**Land at Bilsham Road, Yapton**  
**Planning Reference: Y/70/22/DOC**

**Approval of details reserved by condition imposed under ref Y/91/17/OUT relating to Condition Nos 9 - surface water drainage and 27 relating to levels.**

**At this stage we would recommend that this condition is not discharged at this time until further information is provided and the comments below are addressed**

Drawing Status	FOR APPROVAL		
Client	THAKEHAM		
Project	BILSHAM ROAD YAPTON		
Drawing Title	S104-CONSTRUCTION DETAILS SHEET 1 OF 2		
Scale	NTS	Date	FEB 22
Drawn By		Checked By	
Drawing No.	D1956-15-100		
Rev.	-

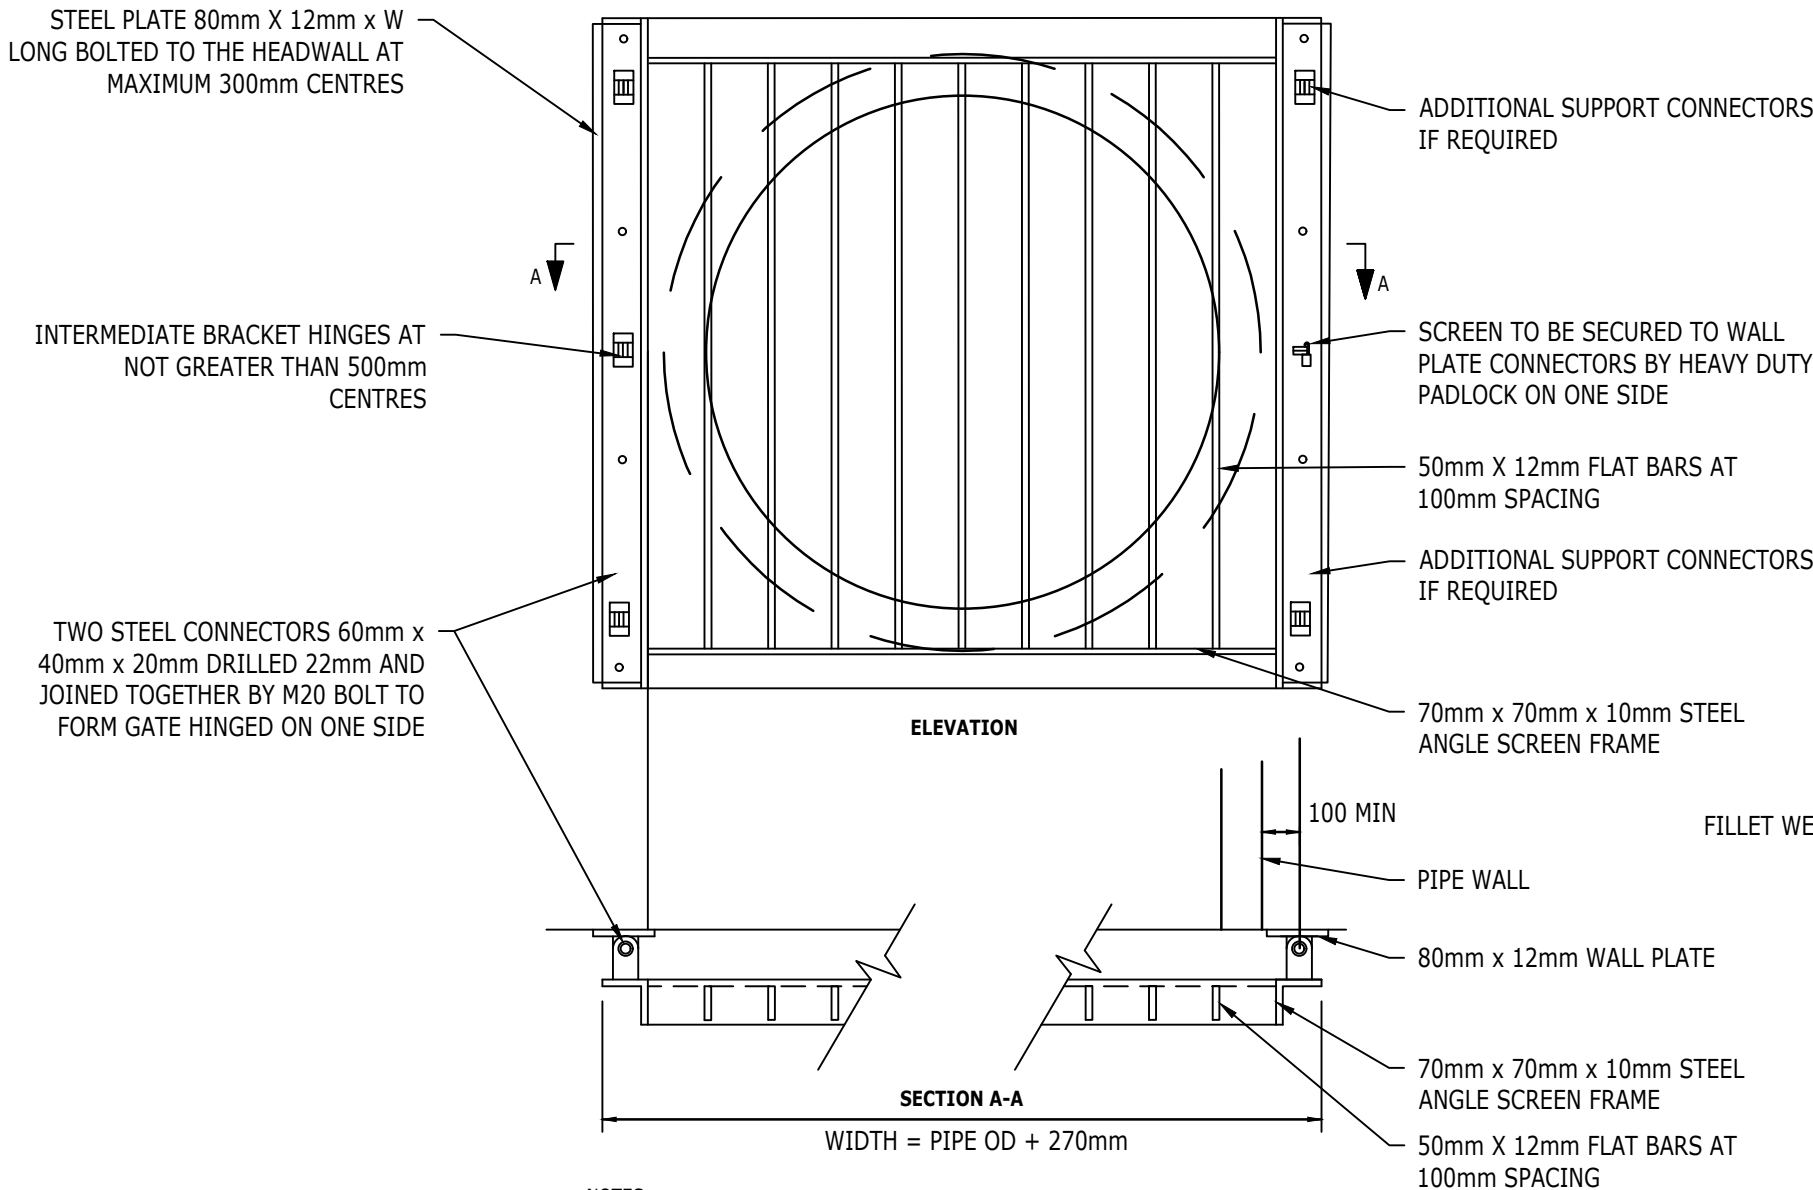
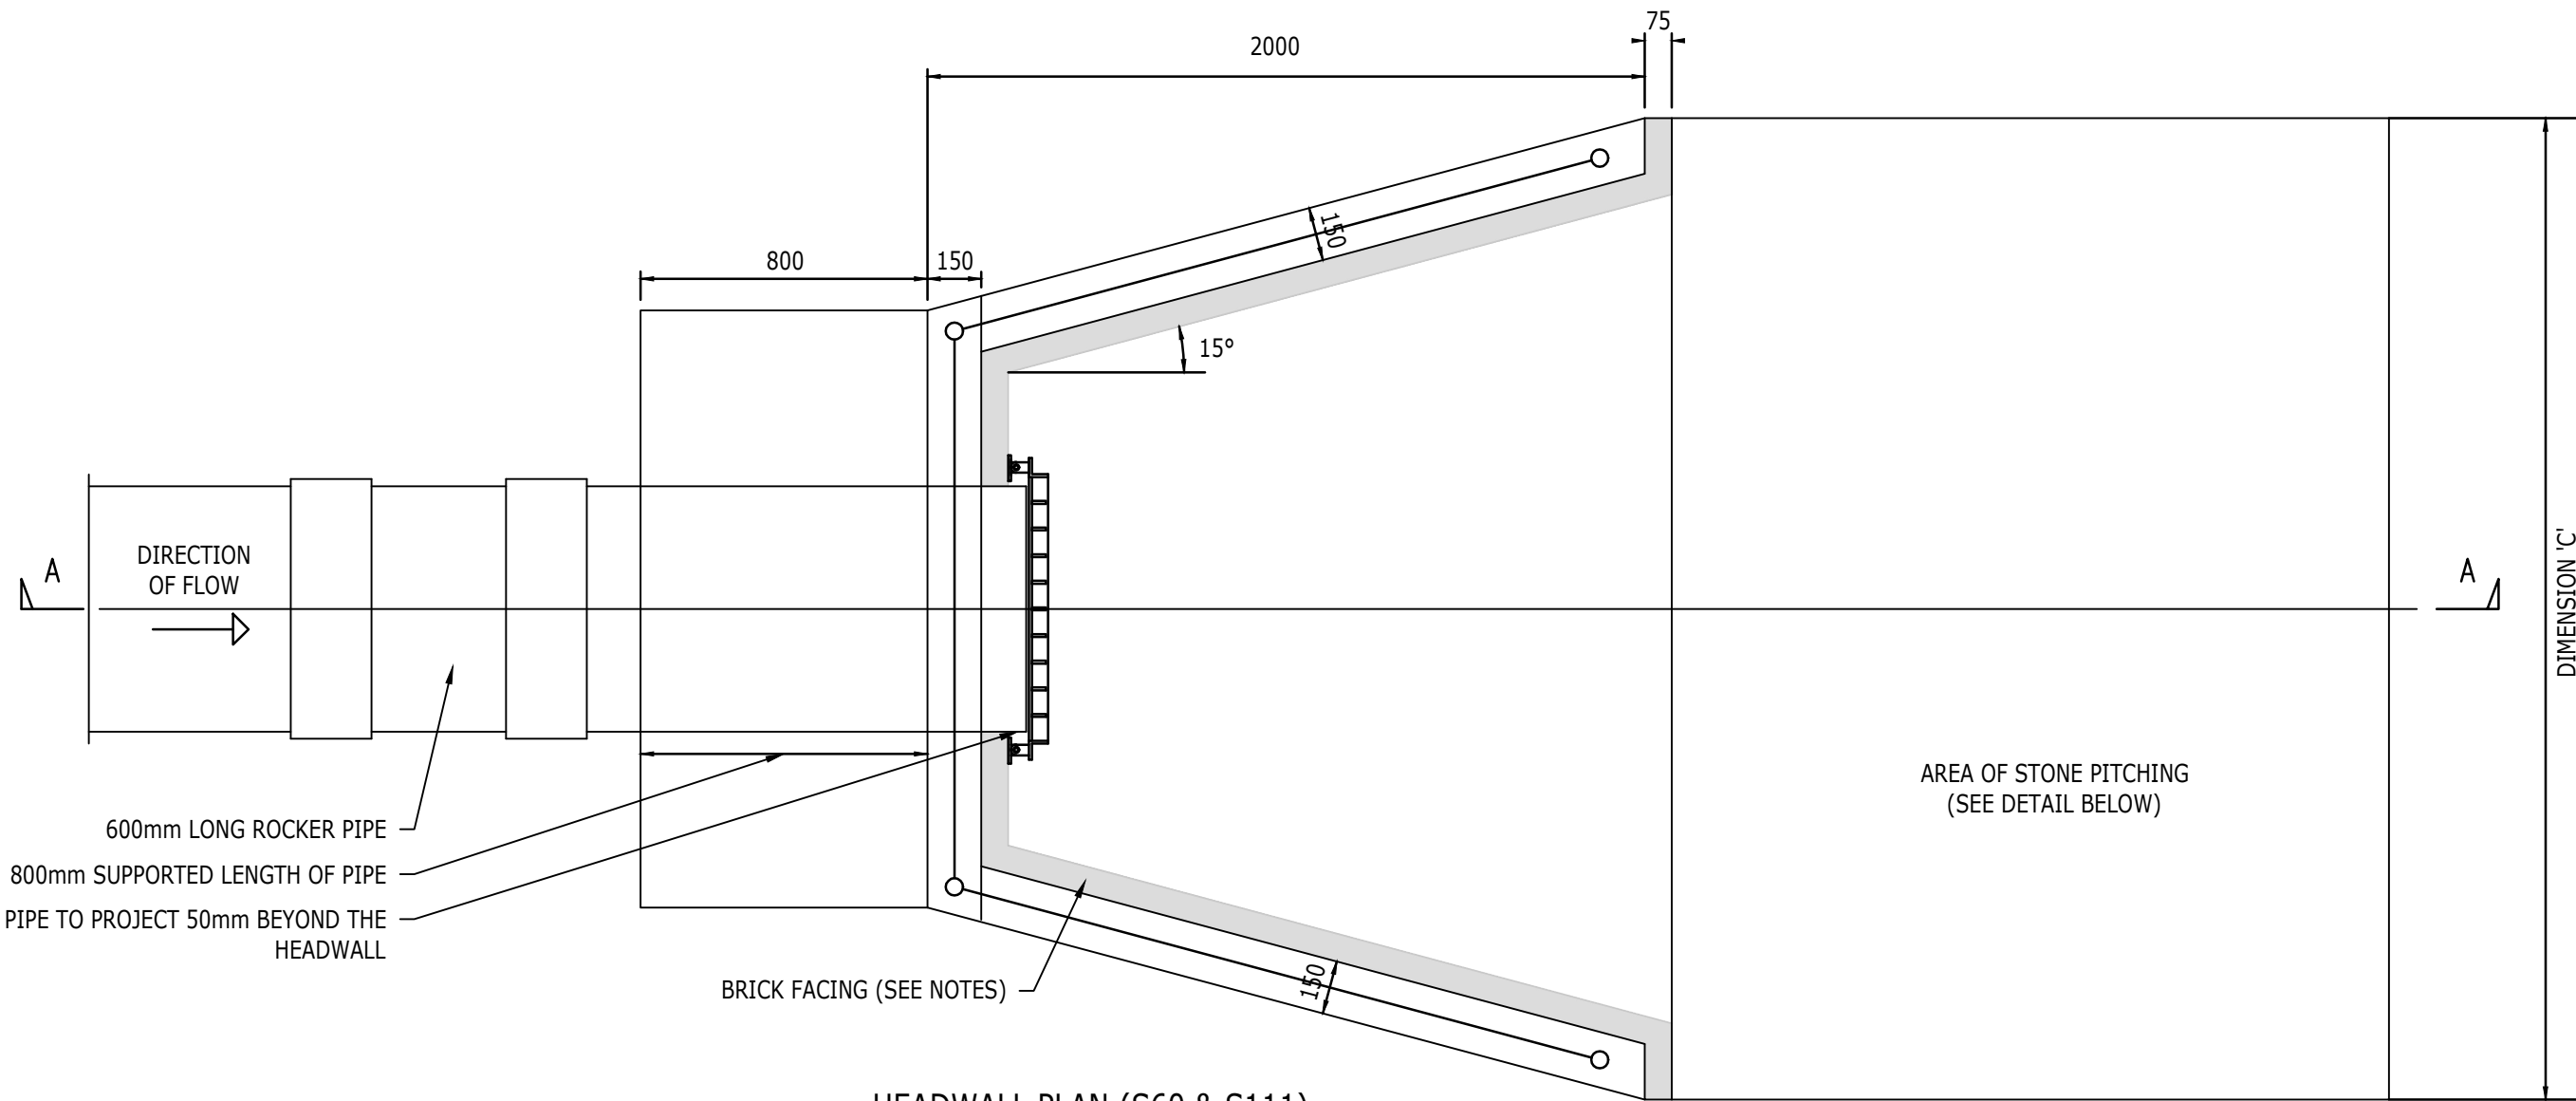
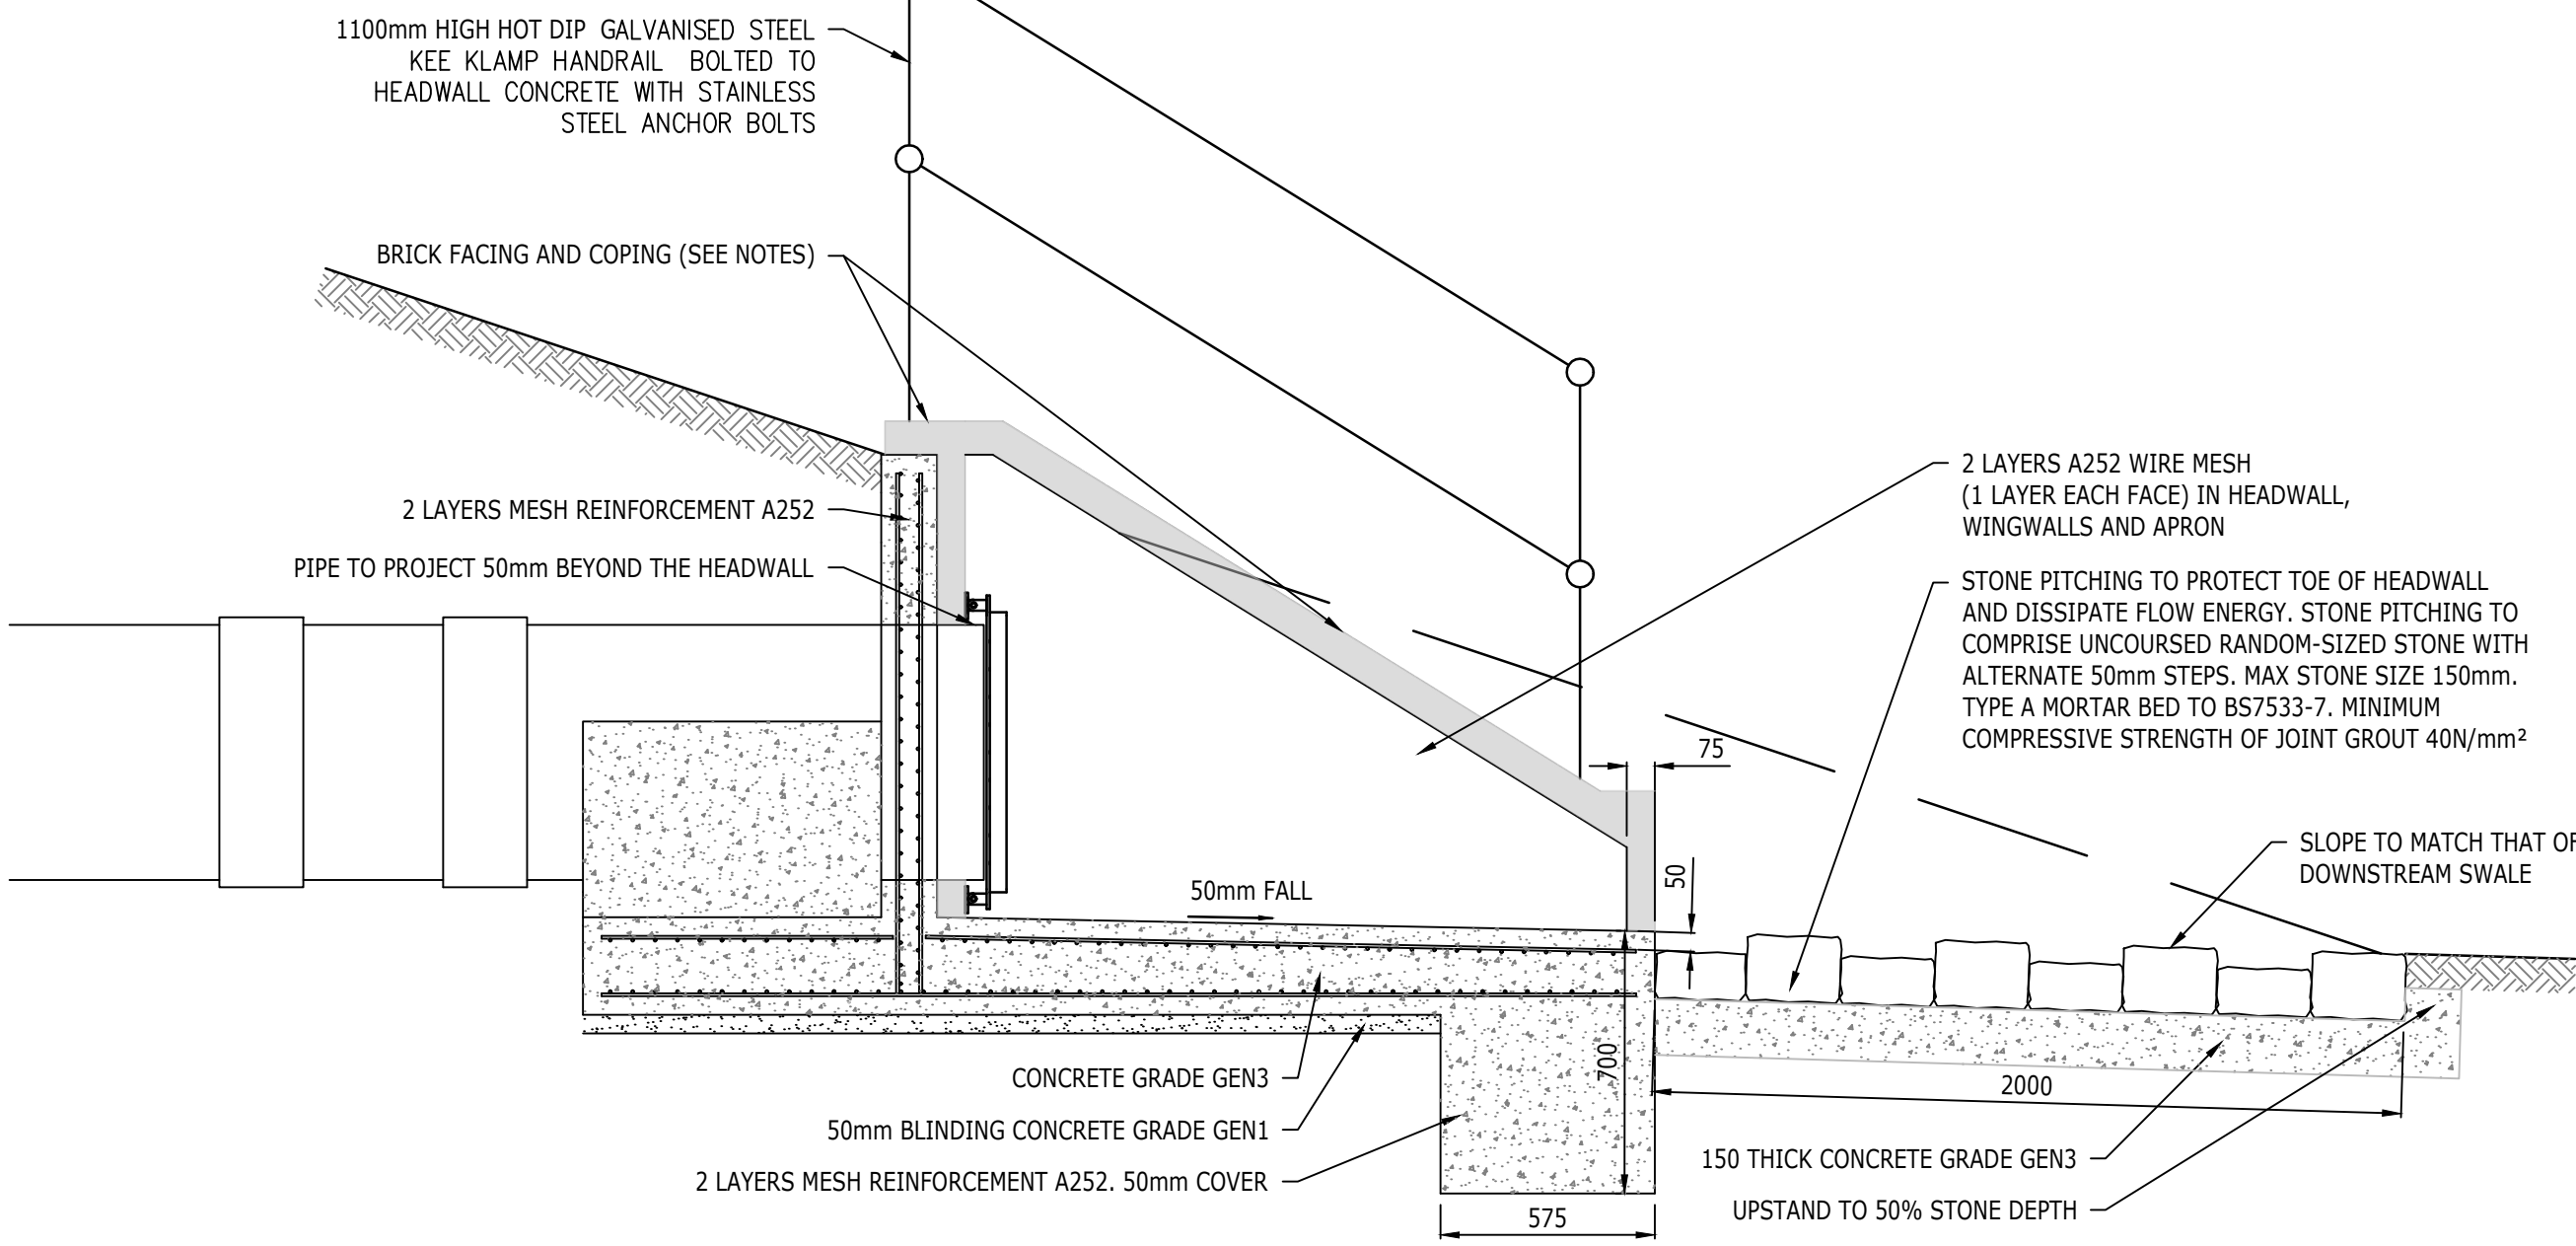
11. *Please provide cranked grilles at a 45 degree angle.* - Cranked grilles required on heads – S104 Construction details sheet 1 of 2 D1956-15-100 needs to be updated to suit ADC requirement. Pipe beddings details on this drawing are illegible in parts. Information needs to be clearly presented. We note that applicant's response that this is not "DSG compliant" however the drawings refer to Sewers for Adoption 7<sup>th</sup> Edition. As such the applicant needs to be clear which edition of Sewer for Adoption the adoptable drainage is being designed to. In addition they should confirm who the adopting authority will be as well as confirmation from the adopting authority on whether they will or will not accept cranked grilles. 08/02/2023- *Whilst is noted that the Technical Approval certificate has been provided for information, this doesn't clarify whether the adopting authority has considered a request to use cranked grilles. This needs to be confirmed by the adopting authority otherwise cranked grilles should be used- 09/07/2023 – We await your submission of the confirmation from the adopting authority or as previously advised this should be amended to meet the requirements of Arun District Council*
